From: Chantelle Bashford [REDACTED]
Sent: 22 April 2022 16:15
To: Planning.Responses <Planning.Responses@arun.gov.uk>
Subject: RE: Planning Consultation on: BR/65/22/L

Application No: BR/65/22/L

Site Address: Salisbury House The Steyne Bognor Regis PO21 1TX

Description of Works: Listed building consent for the change of use of 5 No self-contained flats for adults with learning difficulties to 5 No self-contained flats and formation of 5 No further flats from HMO rooms, garage and office, repairs and decoration of external surfaces, minor alterations to elevation facing Sadler Street, change one window facing rear courtyard to French doors & apply obscure film to 2 windows in courtyard area.

GROUND FLOOR

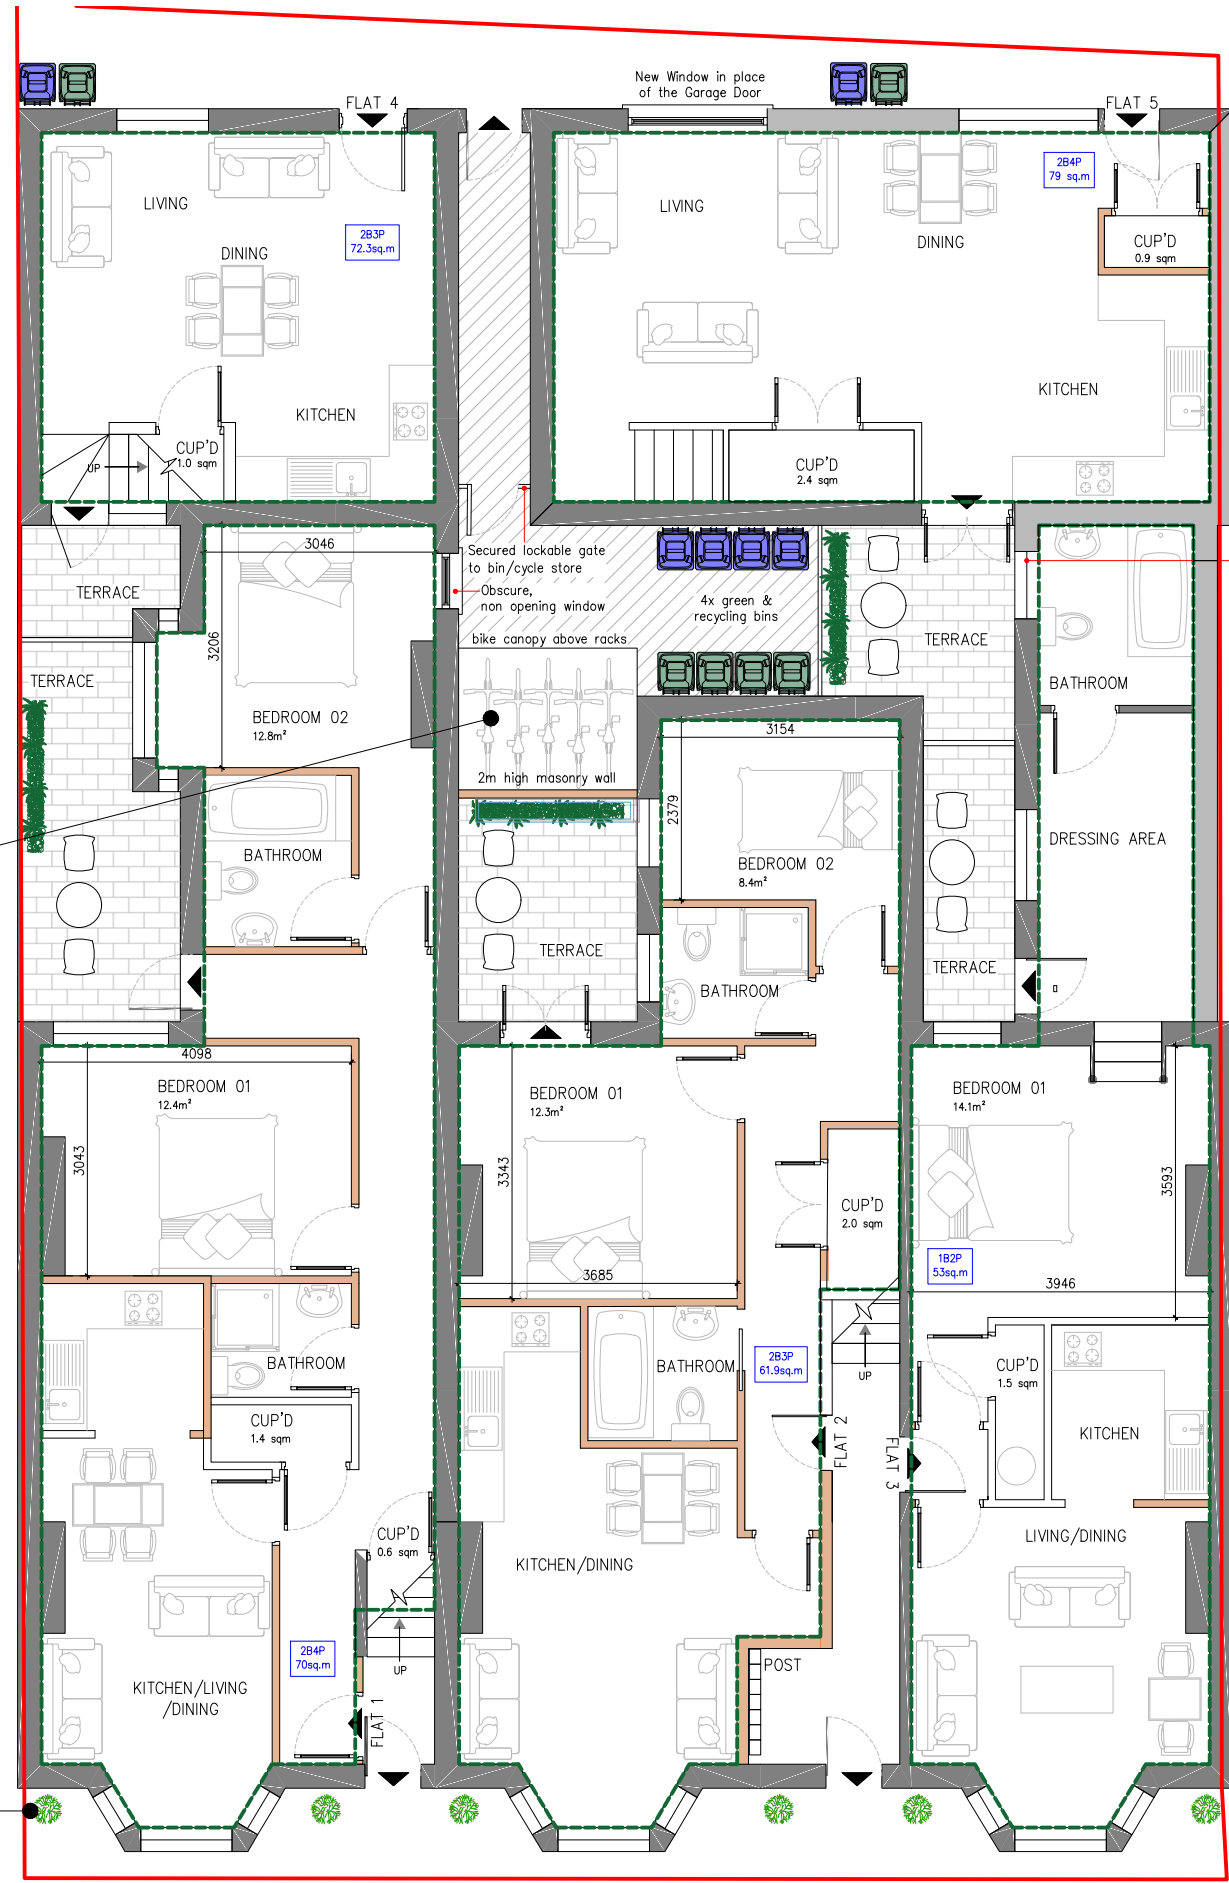
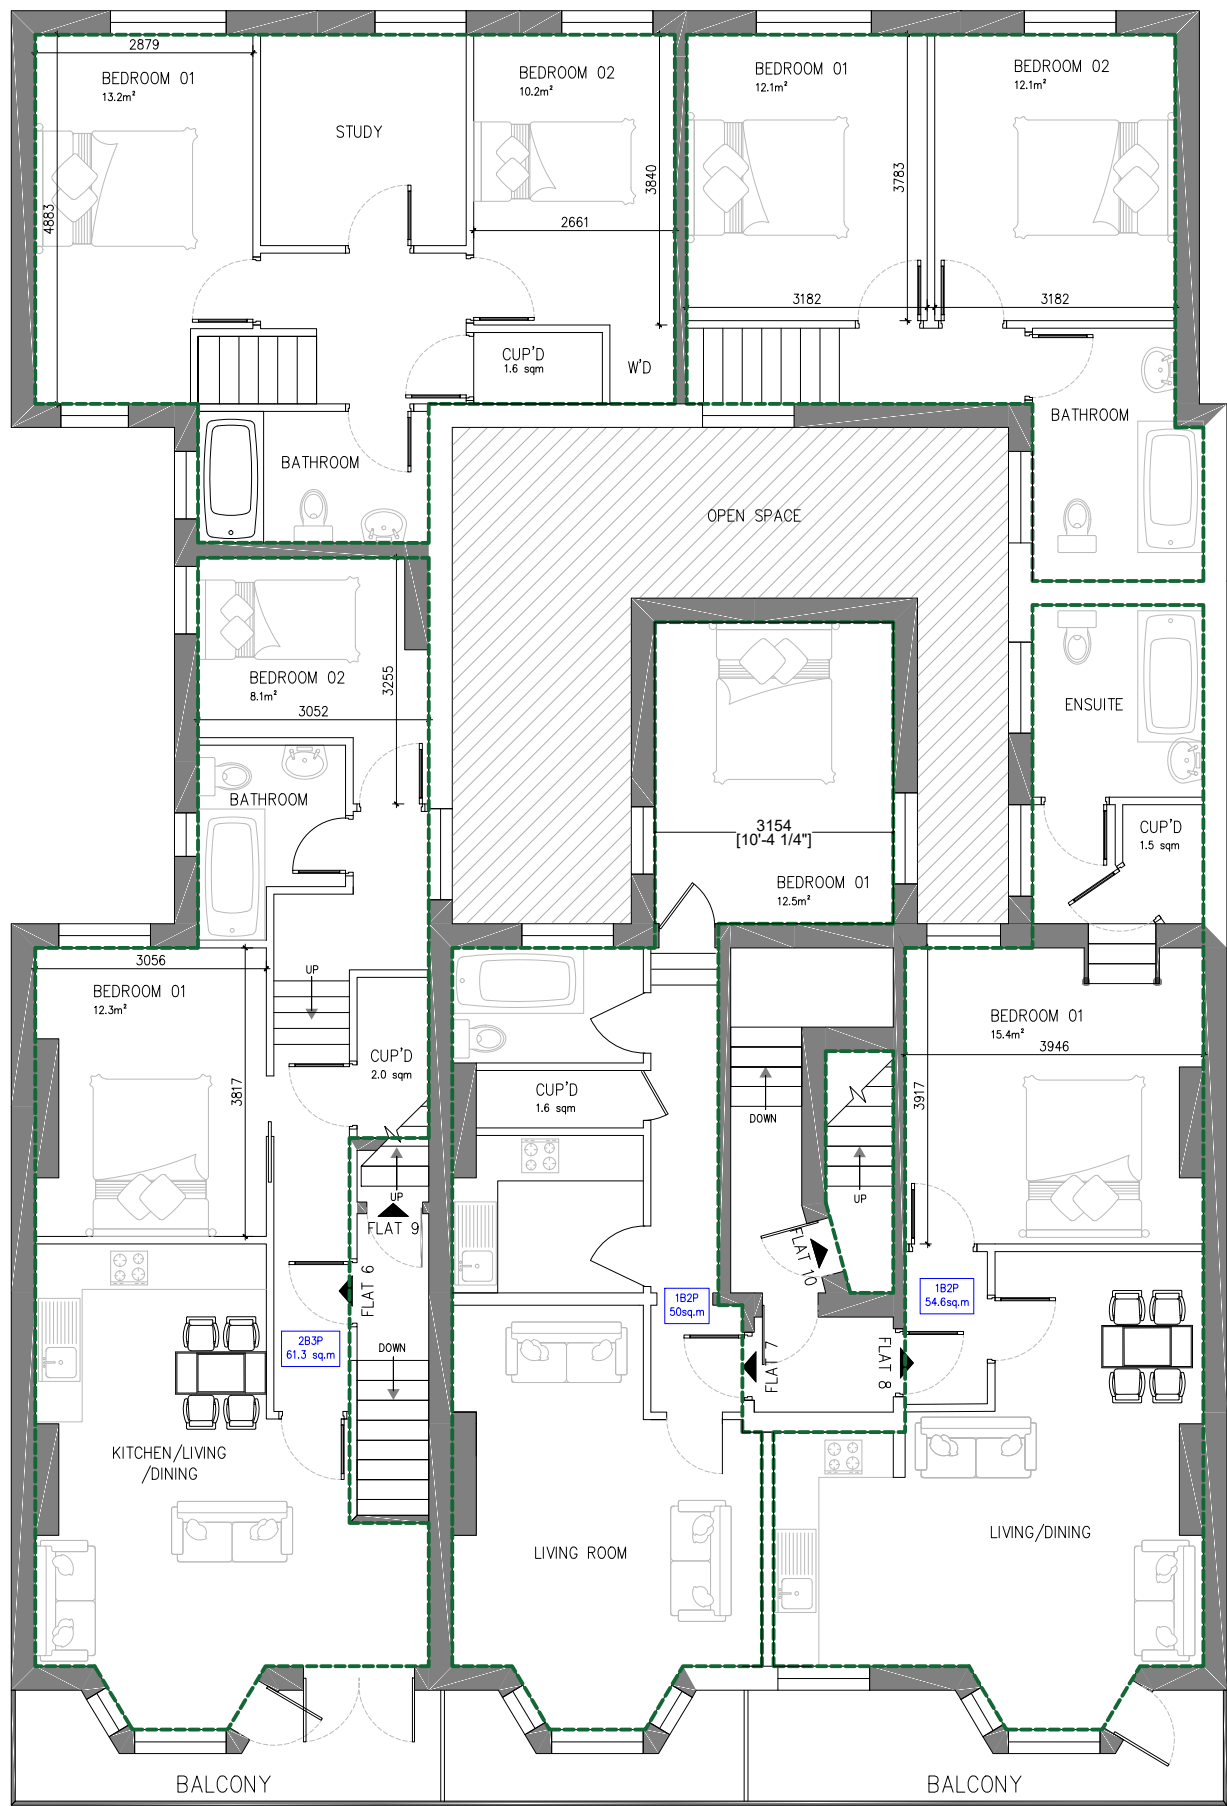
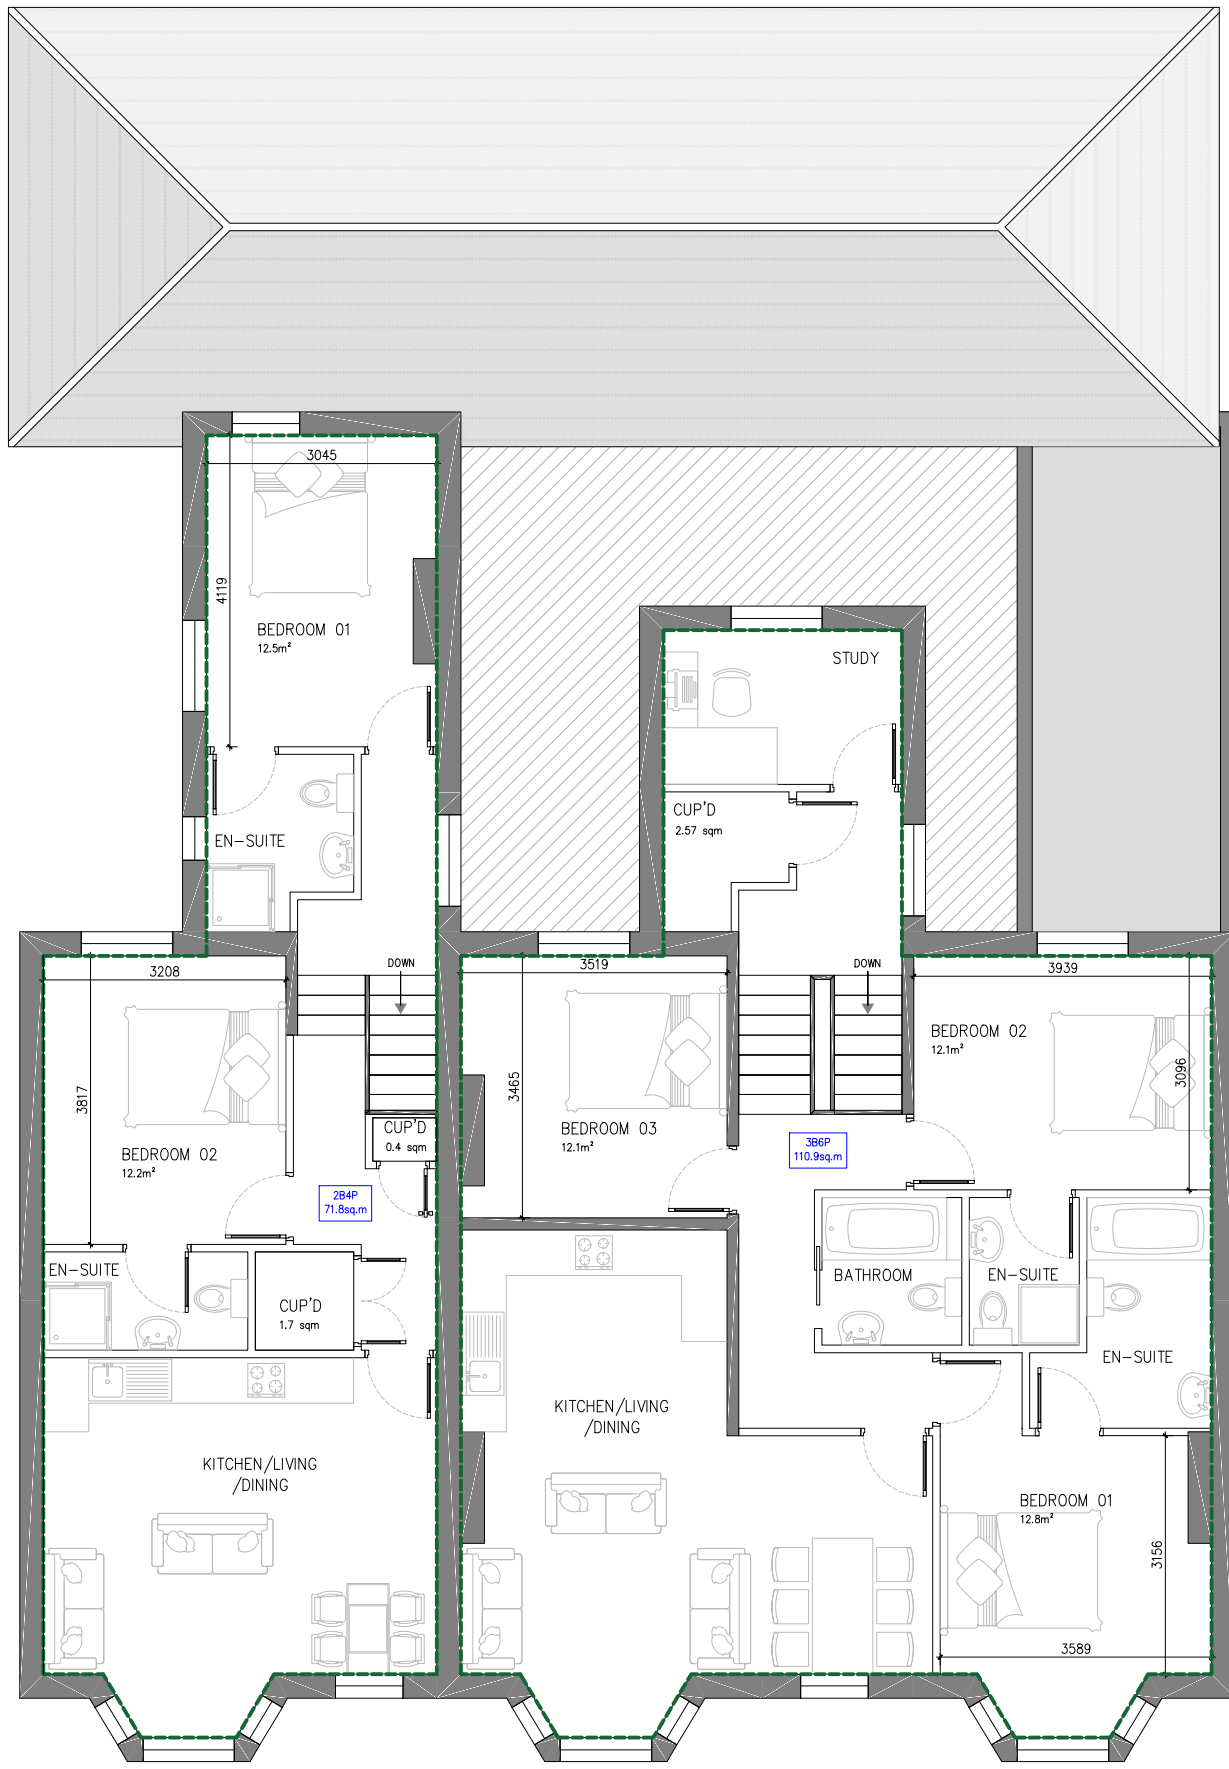
- A room where the only escape route is through another room is termed an “inner room” and poses a risk to its occupiers if a fire starts unnoticed in the outer room. As egress from flats 4 & 5 is via the open plan living room/kitchen, an escape window should be installed to bedrooms 1 & 2 within both flats. An escape window should only be installed if the following criteria can be met:

- The internal escape routes should provide 30 minutes fire resistance, including the provision of 30-minute fire resisting and self-closing fire doors (FD30S) to each flat entrance that opens onto the escape route

- Fire blankets should be provided to all kitchen areas
- Emergency lighting will be required to both escape routes due to a lack of natural and borrowed light

- Kitchens should have adequate mechanical ventilation
- Mechanical extraction should be provided to all bathrooms/shower rooms/ensuites
- The double doors within Flat 2 bedroom 1 provide the only means of ventilation within the bedroom. Consideration should be given to installing a separate openable window light to enable the ventilation to be better controlled. For example, enabling the occupier to have a window open during the night and during prolonged periods of rain
